Cowfold Residents' Comments at Deadline 4

CowfoldvRampion
CowfoldvRampion@gmail.com

Version 1 – 30 May 2024

Oakendene Onshore Substation – Indicative Landscape Plan

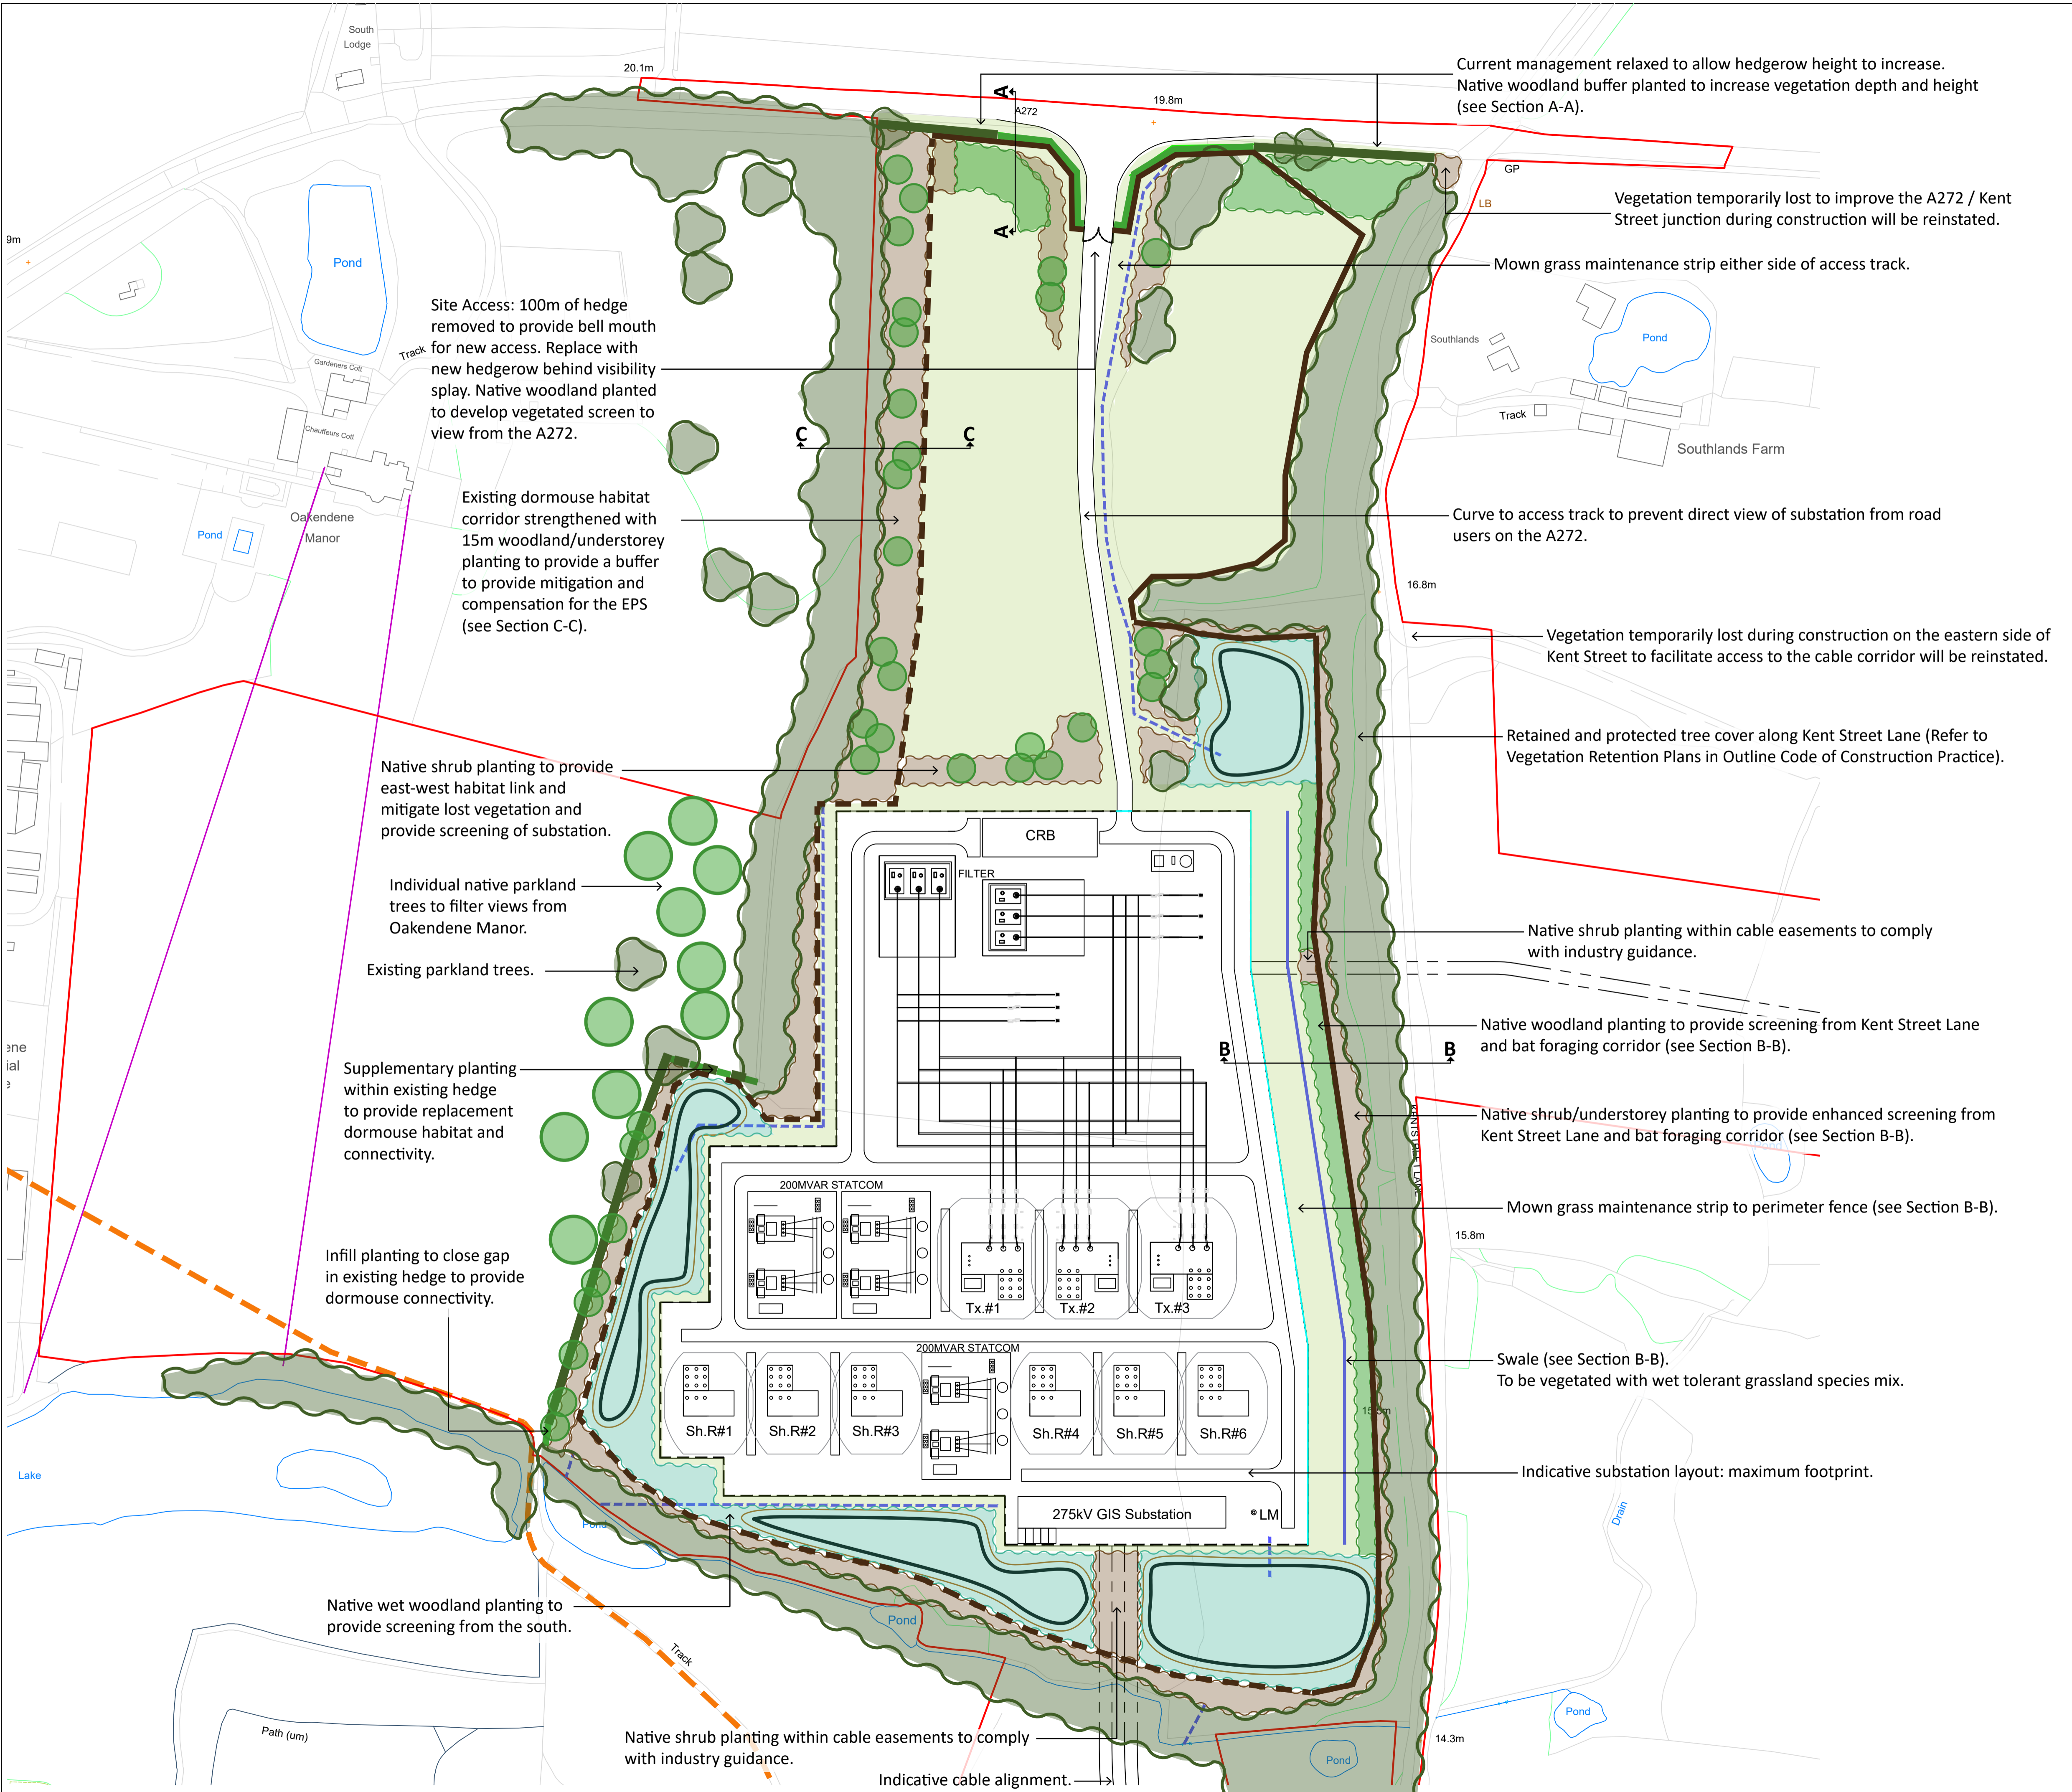
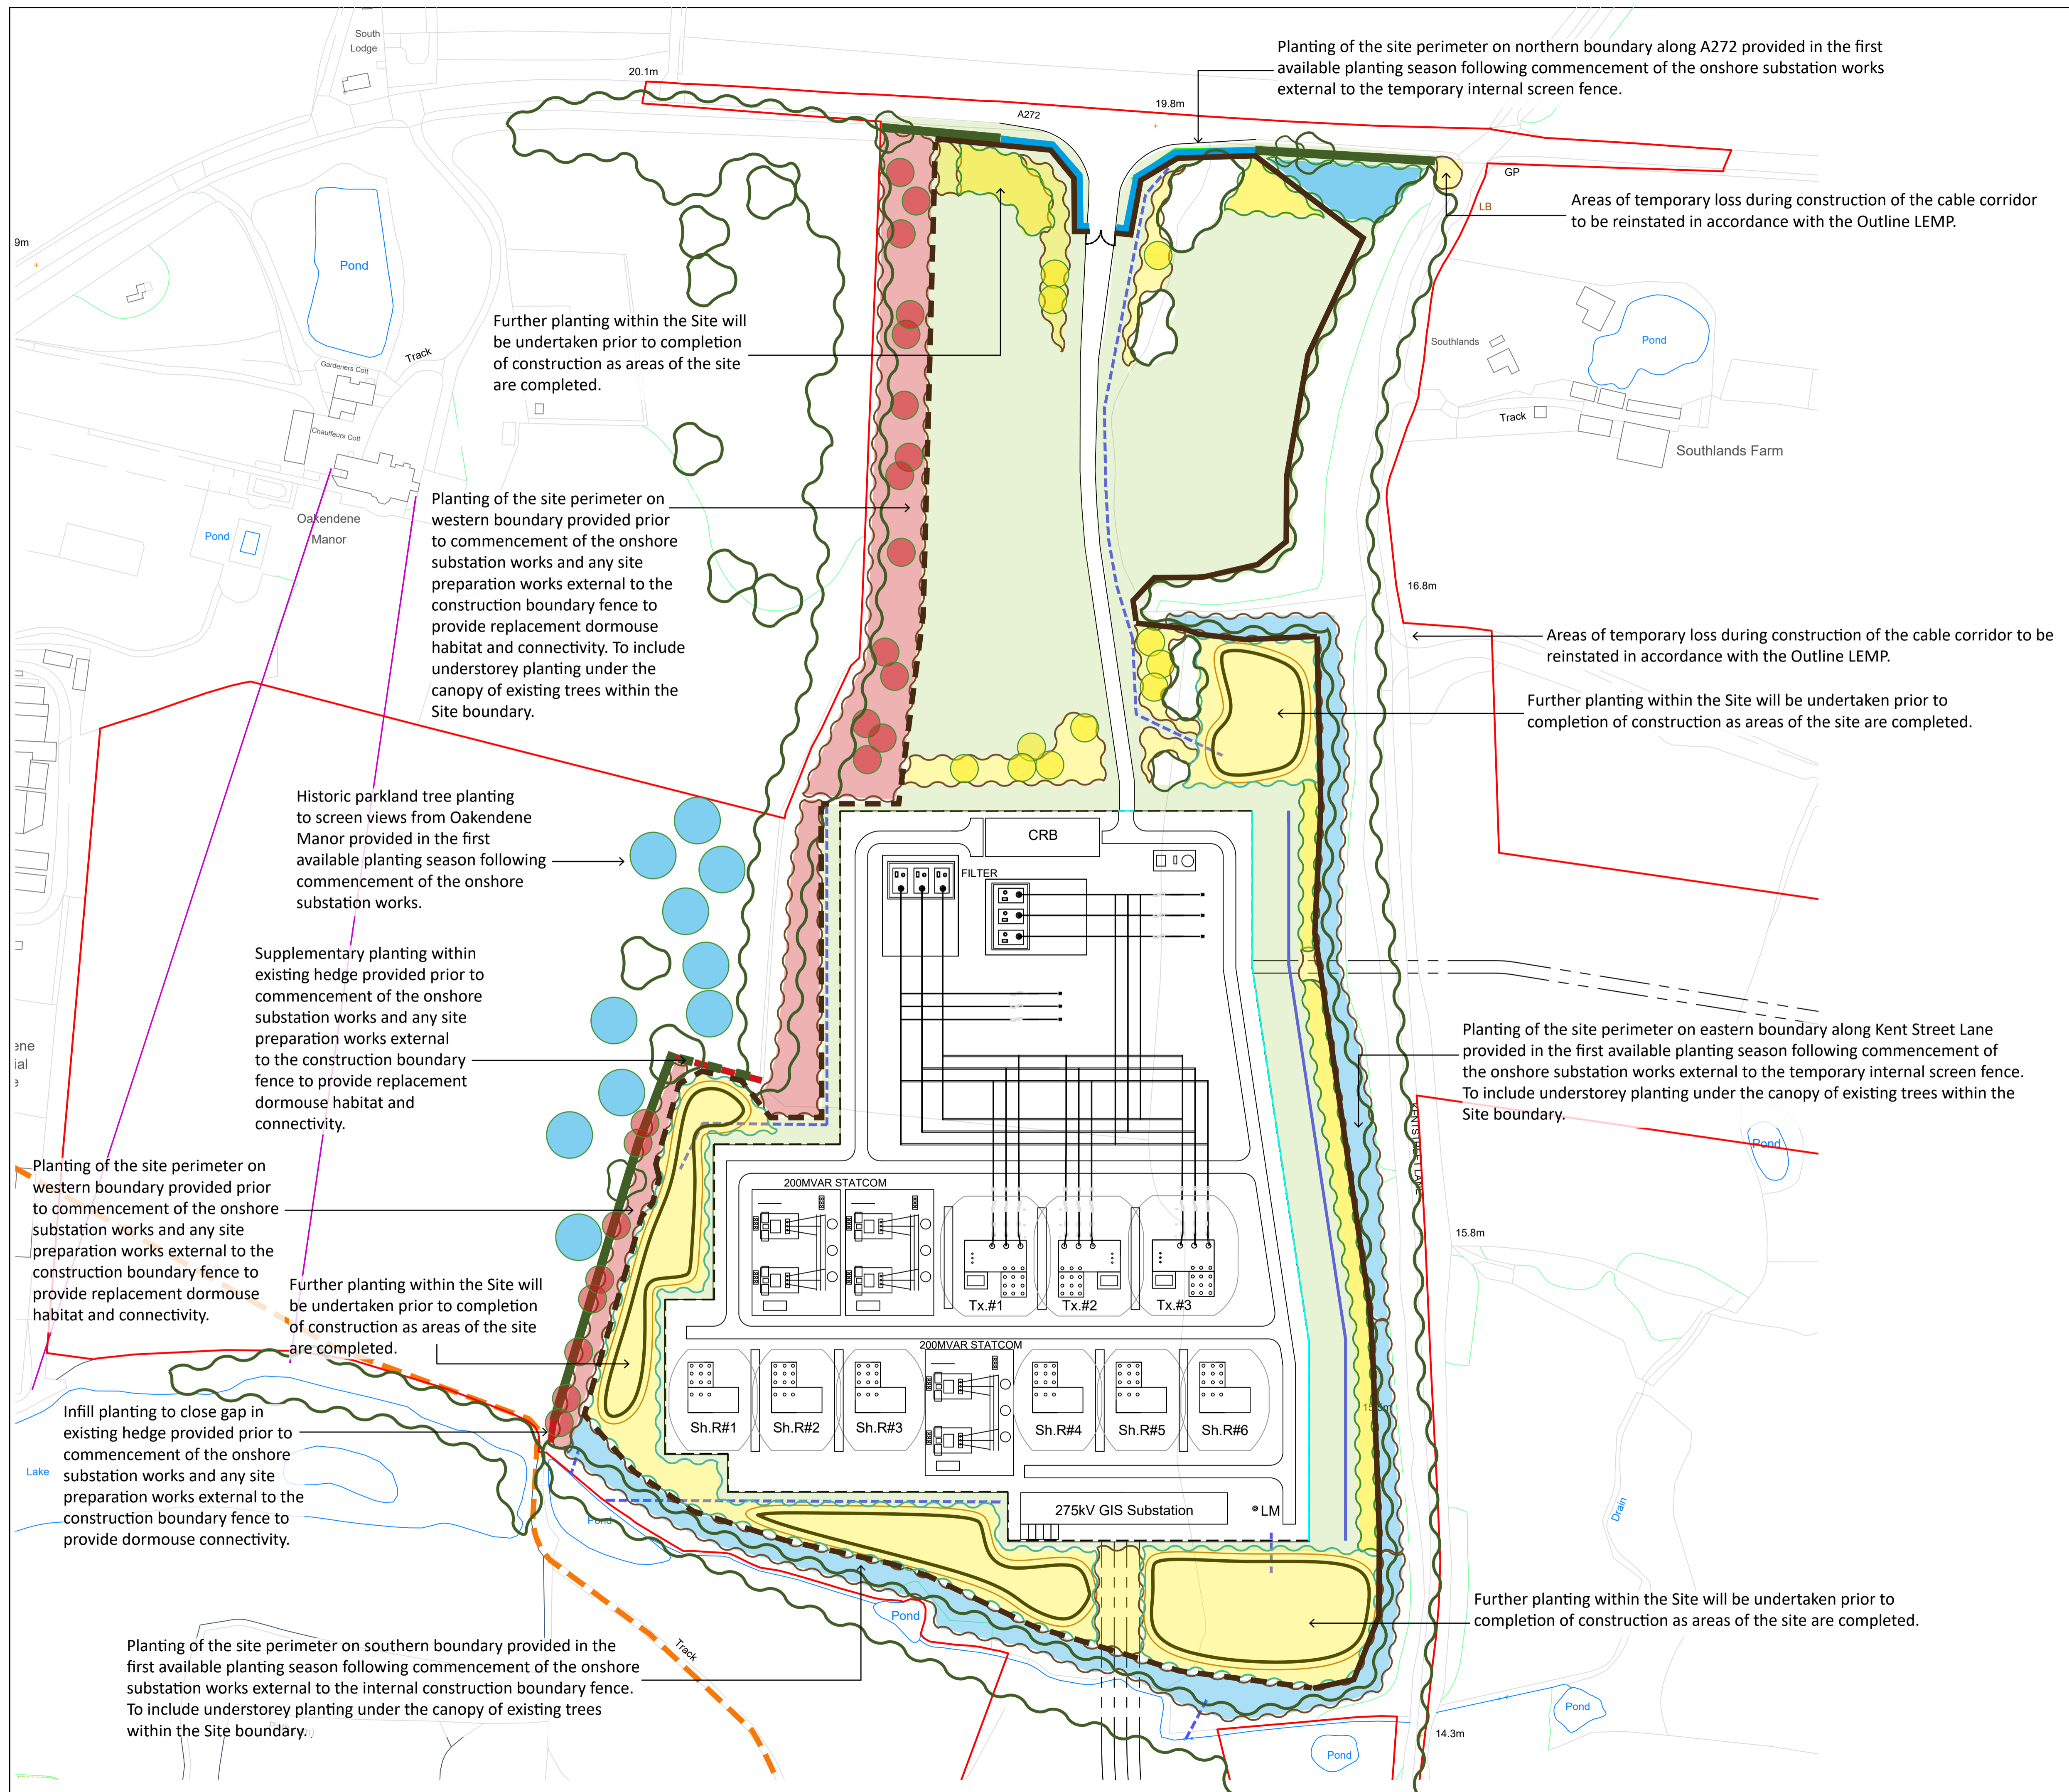
parkland trees will take DECADES to screen effectively from the manor house. **The Design Plans show that in fact most of the area to the north will remain wide open until the end as it cannot be planted up and allow construction to take place around it.**

The Oakendene advanced planting plan is not possible as the North East corner of the substation plot is to be removed under the Kent Street CTMP, also published at this deadline, which requires the removal of a large area of hedge, trees and scrub at this point to create a huge turning arc. This is another example of lack of joined up thinking between Rampion documents
